Formal Objection to Application Reference: BR/255/18/HH- 30 Mansfield Road.

Date: 04.11.18

PROPOSED ROOF PLAN

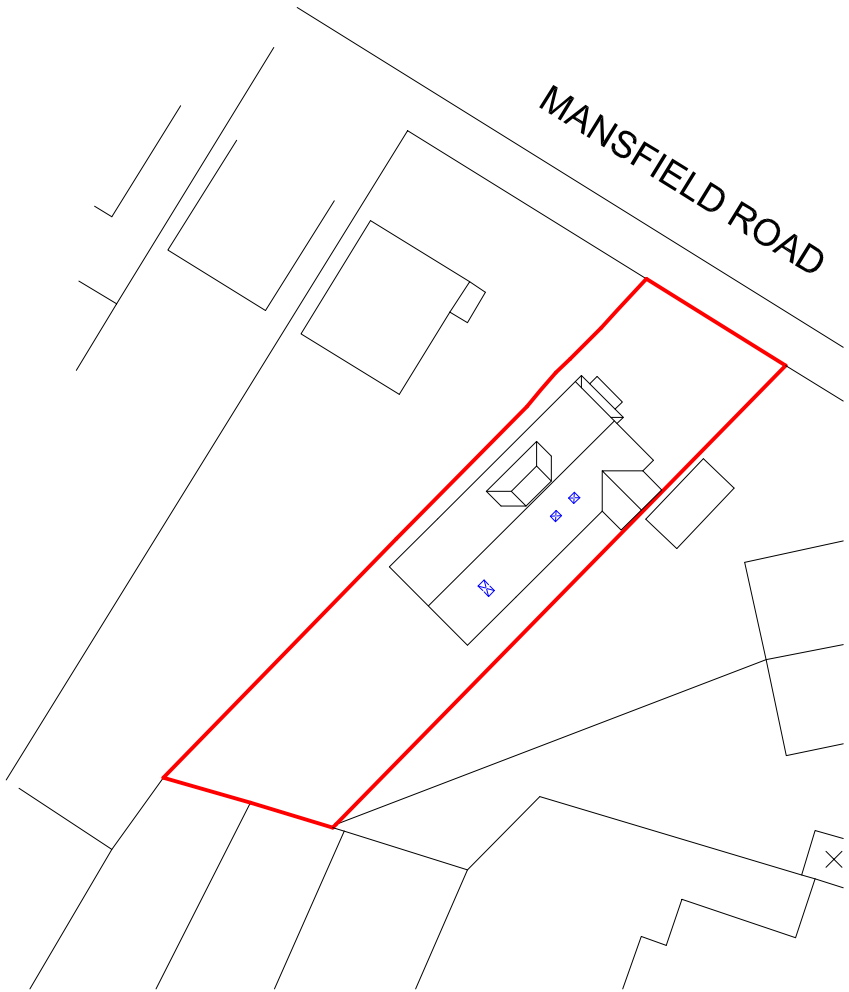
Under the original application BR/305/17/HH it was justified that the works complied with policies GEN7 and DEV19 however we would disagree with this when taking into account the full extent and size of the works proposed at No 30. Over the course of time the works have altered the roof form, have raised the ridge height and now propose a 3m deep extension at first floor. This combined bulk on No 30 creates a stark side elevation that is neither in keeping to the locality of Mansfield Road nor subservient on No 30- aspects that both policies seek to achieve. Combined with the close proximity of the development to the shared boundary with No 28 the works shall appear oppressive and over-bearing from our home and create an un-neighbourly impact as a result. It would also be noted that this goes against the National Planning Policy Framework, GEN7 and DEV19 guidance

We would like it noted that had the applicant carried out the original development as approved under BR/305/17/HH then alongside the obscure glass and fixing shut of the dormer windows we would have considered the development to be in a reasonable form. However, with the height of the hip as proposed a strong impression was given that this roof was to be used as a sun terrace. This fear of the area being used in this way has lead the applicant to now apply for the full roof works, removing the site as a terrace but increasing significant mass and bulk instead.

PROPOSED FIRST FLOOR PLAN

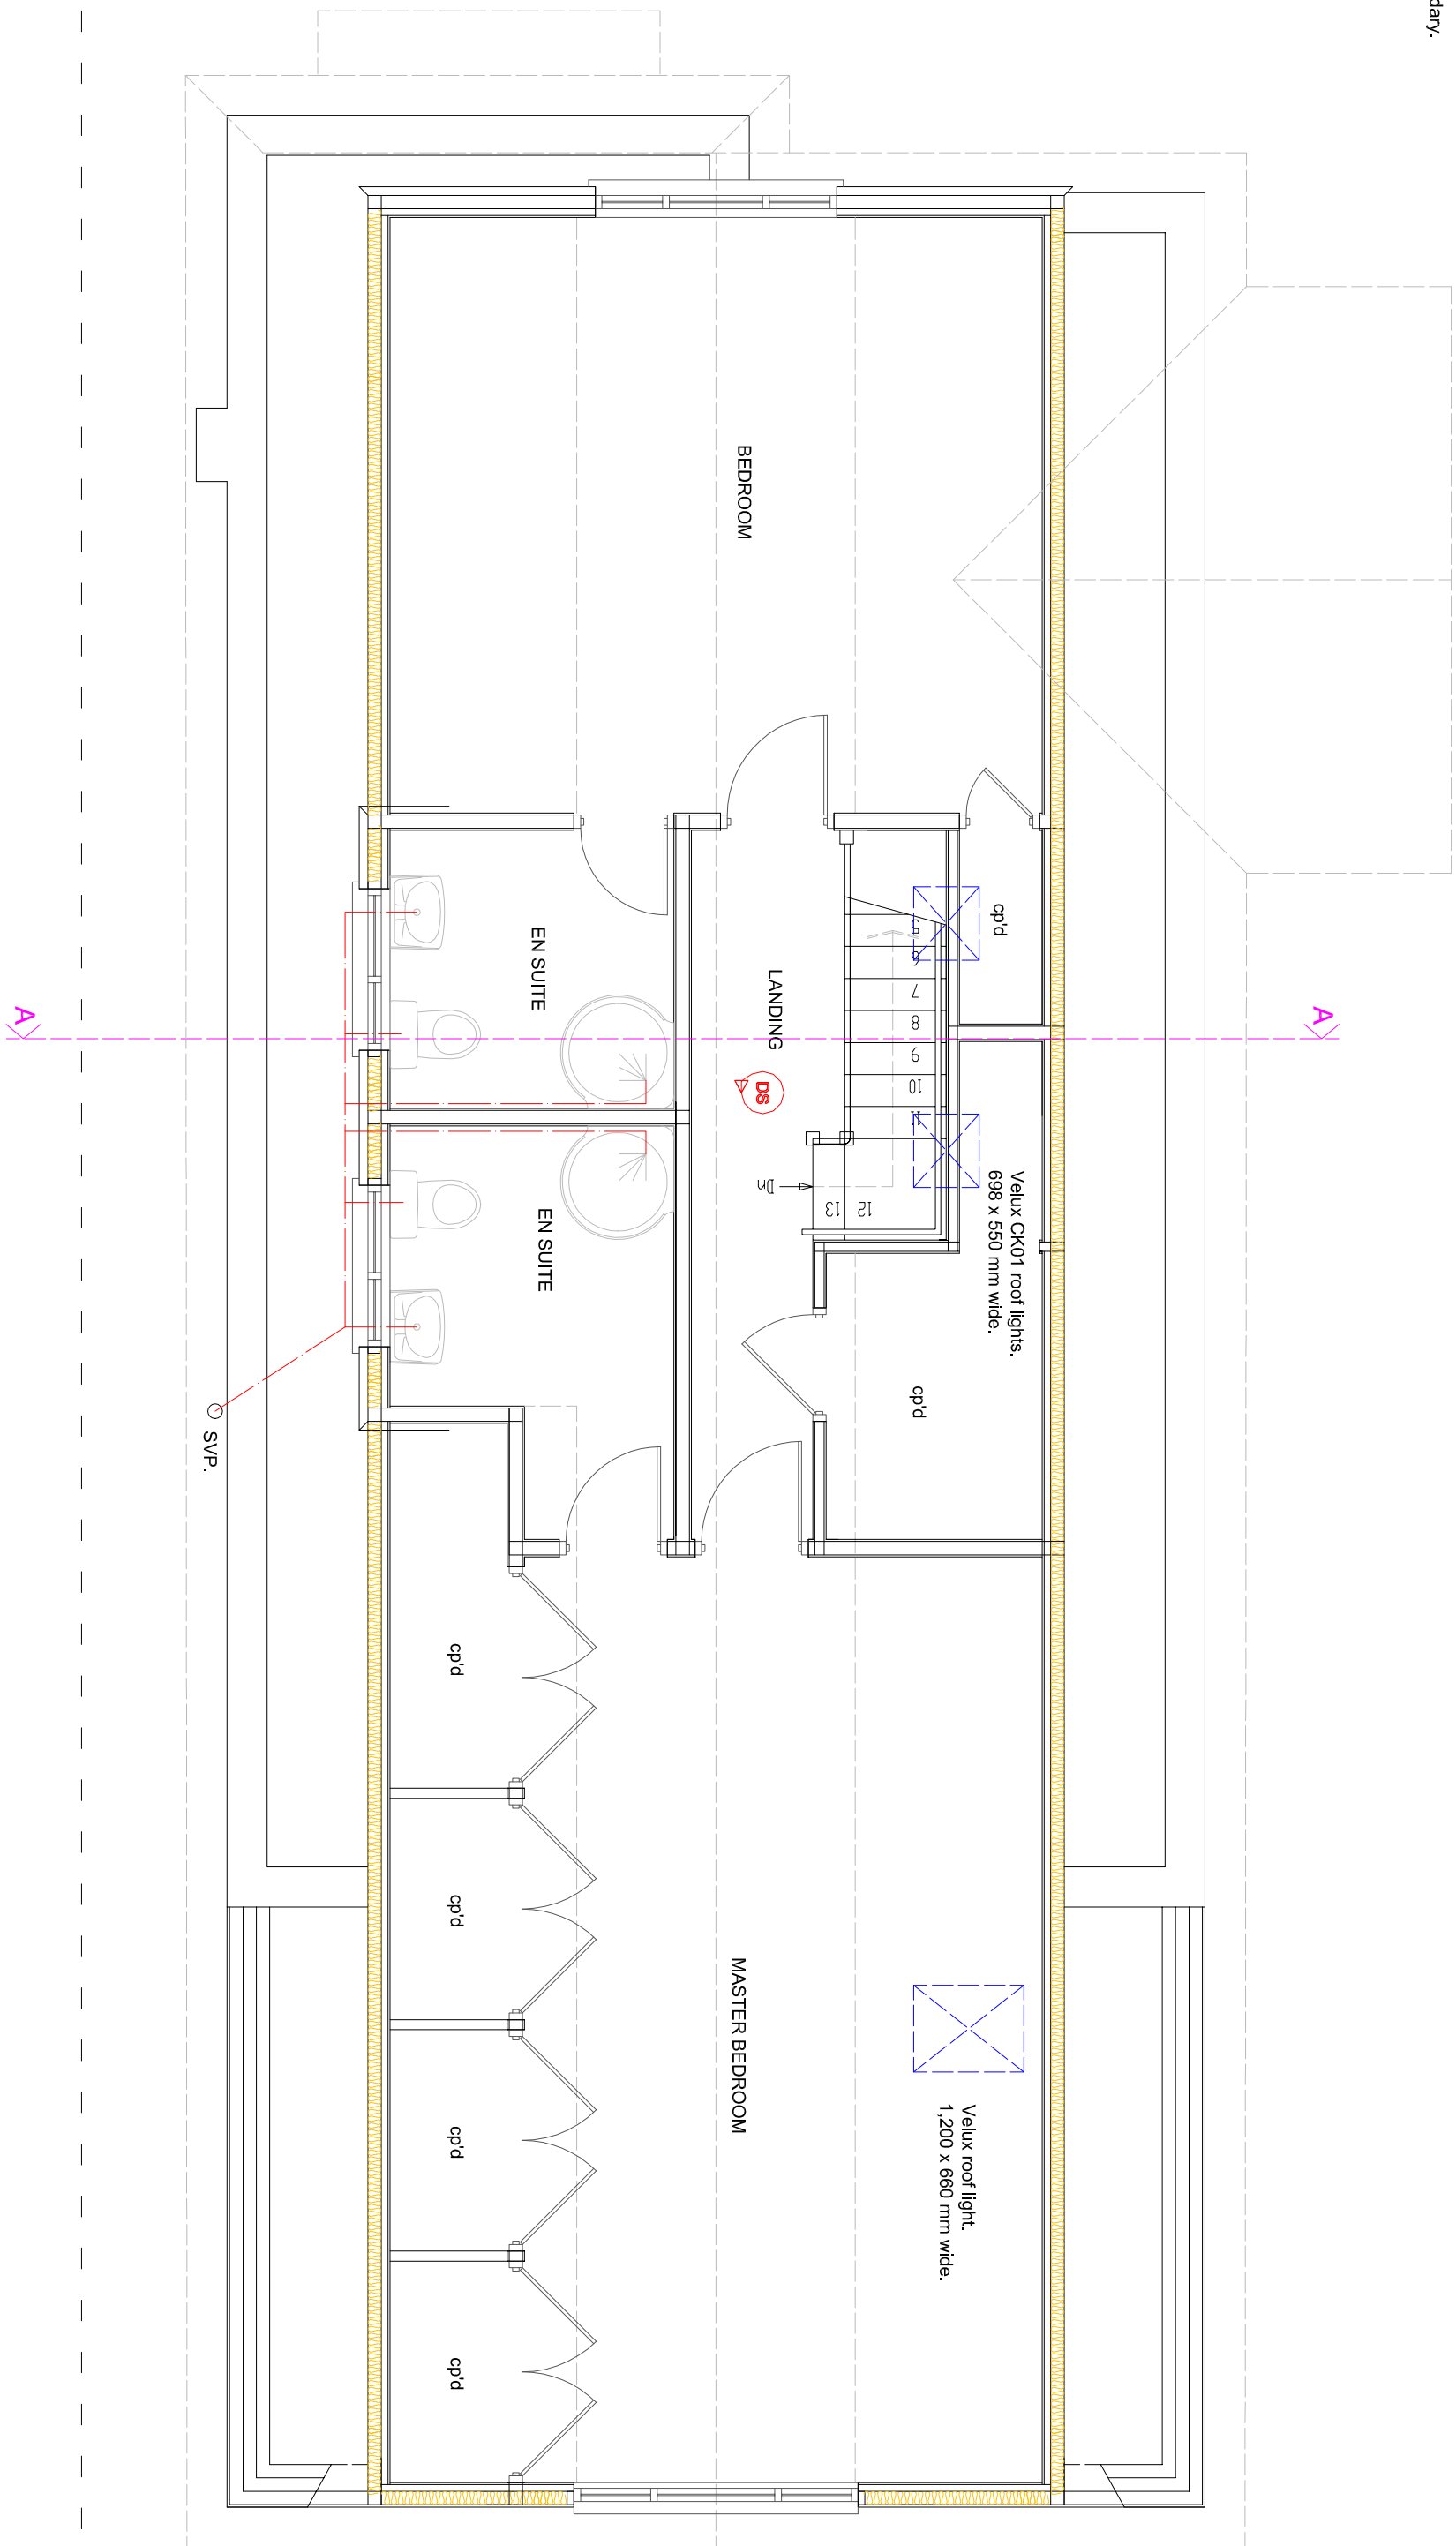
However this does not seem to have been carried out under both past applications and this development has now been completed. Although fitted with obscure glass there is strong concern that the windows are openable under 1.7m from the proposed finished floor levels which shall cause us to be over-looked and our privacy lost. Application BR/255/18/HH does not annotate or show anywhere with supporting statements that obscure glass and fixing shut these windows are proposed. Therefore we would ask the case officer to seek clarity on this, have the plans updated and condition this either to be done, retained, or carried out retrospectively under a modest timeframe. We would appreciate an update on this prior to any formal determination of the application and do not consider that windows fitted with obscure glass but openable protect our privacy levels sufficiently. The windows must be fixed shut also.

It has caused a dis-trust between neighbours and caused significant stress and anxiety throughout. It is considered that a much smaller scale development could achieve a generous bedroom size at first floor without the need for the overly large bedroom with substantial cupboard space which at a cost results in the poor and bulky design of No 30 and causes a significant adverse impact to neighbouring dwellings. Therefore we ask that any case officer takes a detailed and sensitive approach to assessing the plans to ensure that the applicant is applying for all the works required to ensure a deviation or alteration from proposed plans does not occur in future.

PROPOSED ELEVATIONS

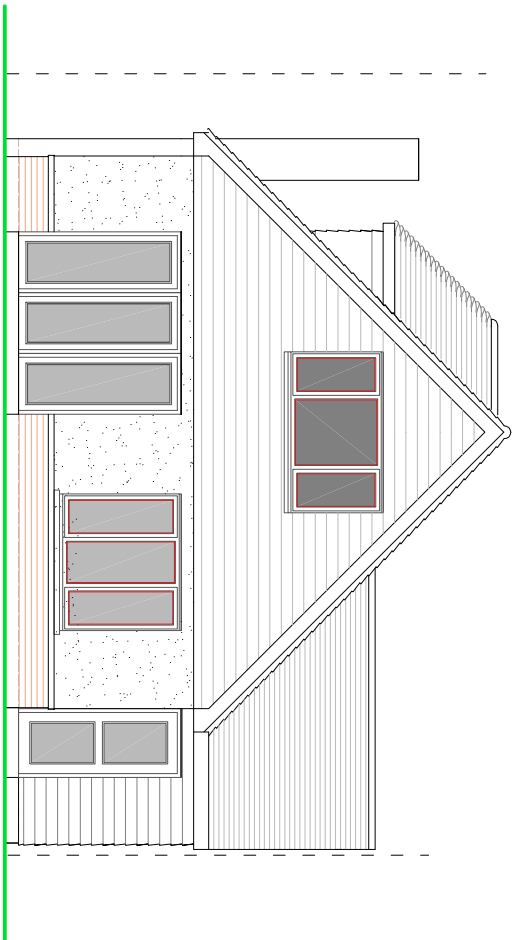
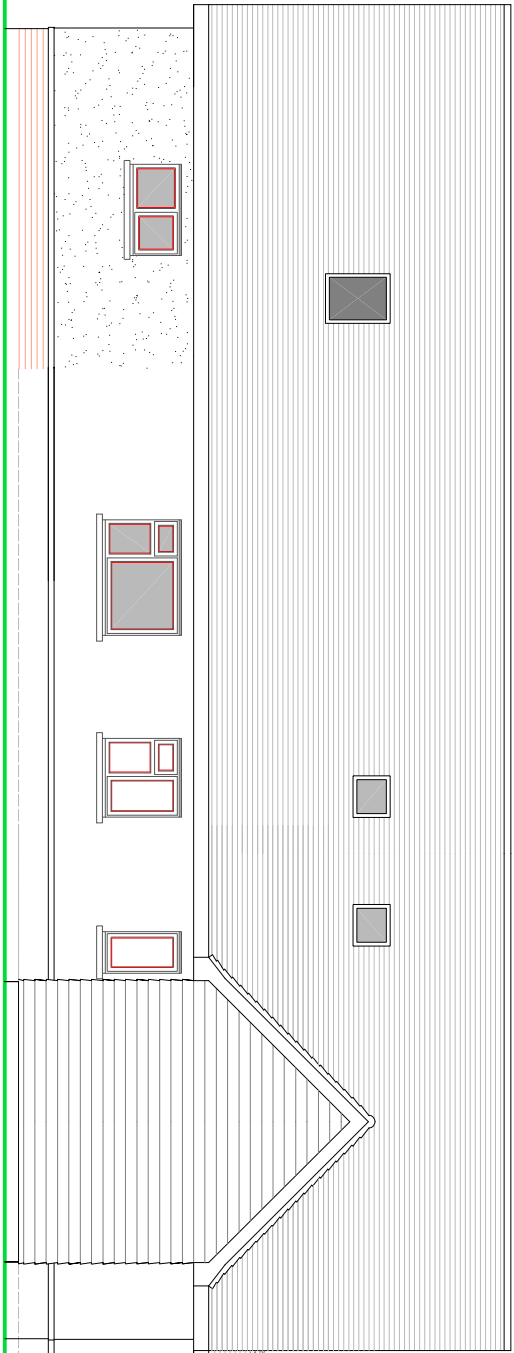
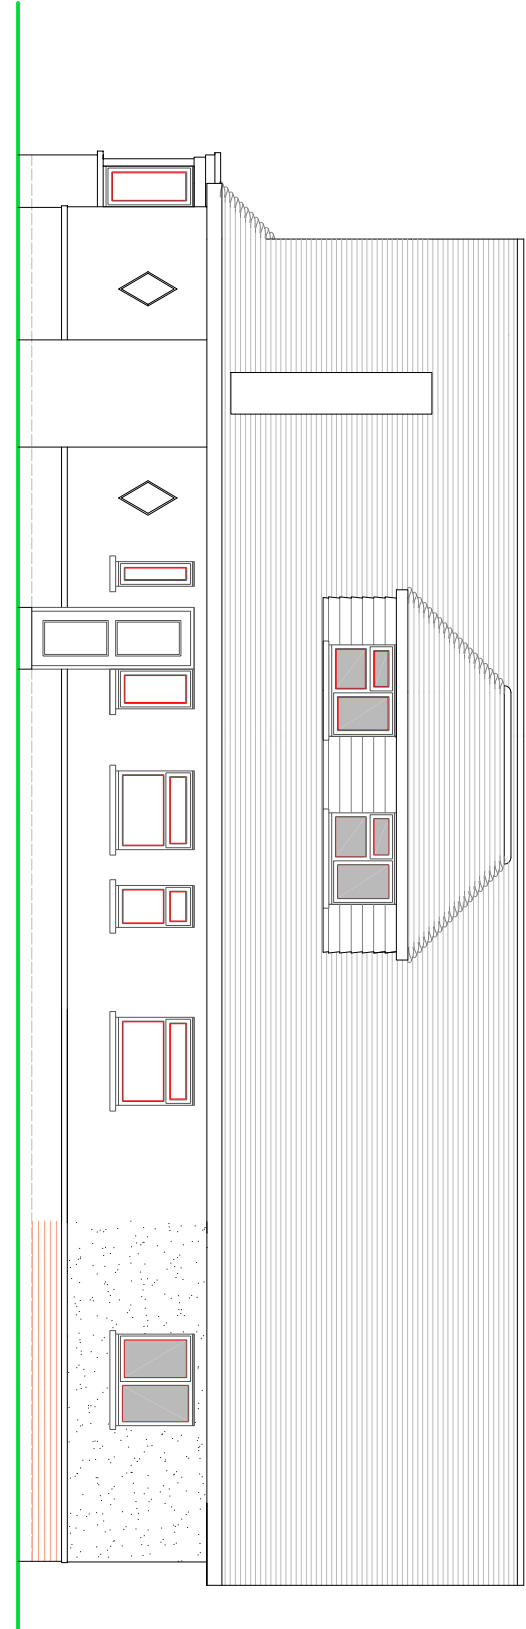
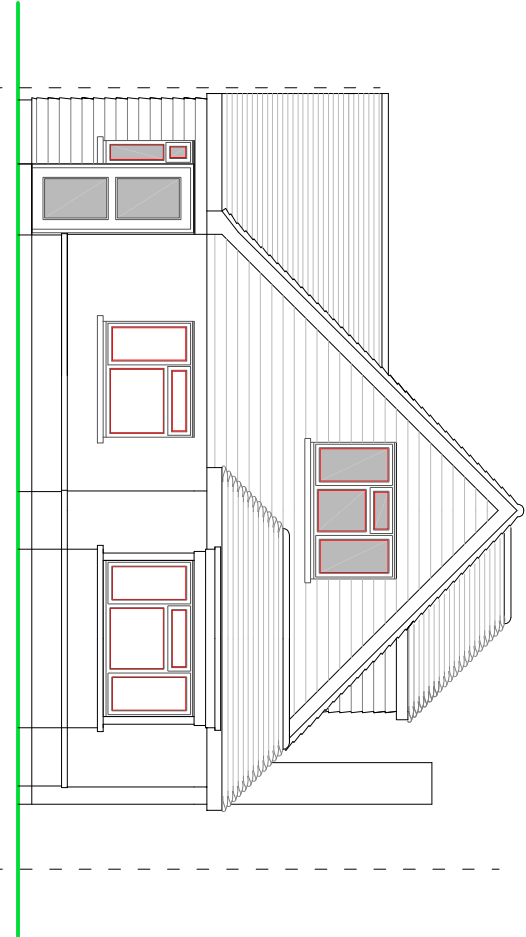
It is our belief that the roof finish to the ground floor rear extension was never for cosmetic purposes but to use the area as a sun terrace via the Juliet doors.

In an ideal scenario we would have preferred a lower hip roof surrounding the ground floor extension to be reduced in height and a condition attached to this approval preventing the area to be used as a terrace and/or balcony. Or the design could have been altered under request of the Local Planning Authority to show a window instead of double doors and Juliet balcony. If this application, as hoped, shall be refused we would like the use of the roof to the ground floor extension restricted so it is not to be used as a terrace/balcony.
